DECISION DELEGATED TO HEAD OF PLANNING
DECISION DELEGATED TO HEAD OF PLANNING
DECISION DELEGATED TO HEAD OF PLANNING

Application No:	H09-0337-22	Applicant:	Gleeson Homes
Proposal:	Details of existing & proposed site levels, cross sections and boundary treatments (Conditions 10 & 12 of H09-0786-22)		
Location:	Land North Of Northons Lane Holbeach Spalding		
Terminal Date:	21st June 2023

This proposal seeks to discharge conditions 10 and 12 of planning approval H09-0786-22, relating to details in relation to existing and proposed site levels, cross sections and boundary treatments.

Drwg No. 3117-A01-01 Rev H
Scale 1:500 @ A1 Date 27.6.22
Drawn by MB Checked by MR

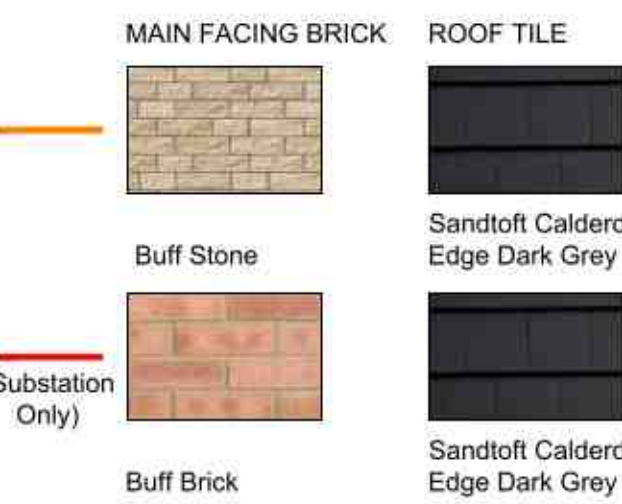
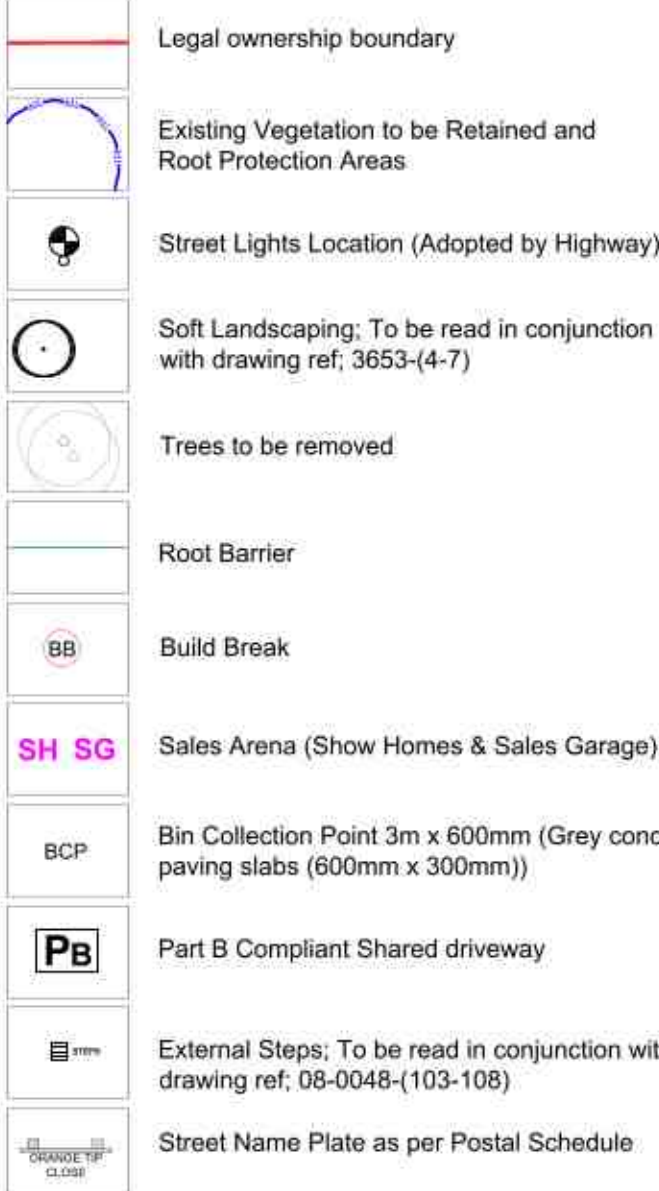
Boundary treatment details have been submitted, with revisions also forthcoming as a result of continuous dialog between officers, the developers and representation outlined by residents. A site meeting has also taken place, allowing a walkthrough of the site to assess both land levels (including resultant garden levels) and the proposed boundary treatments.

The most recent amendments, which includes 2.0 metre high fencing with a 0.3 metre high trellis

above to the rear boundaries of the eastern and southern plots, including those neighbouring Cedar Drive, Spruce Close and Oakwood Glade etc. The amended details, which have been subject to this recommendation, are considered to be acceptable.
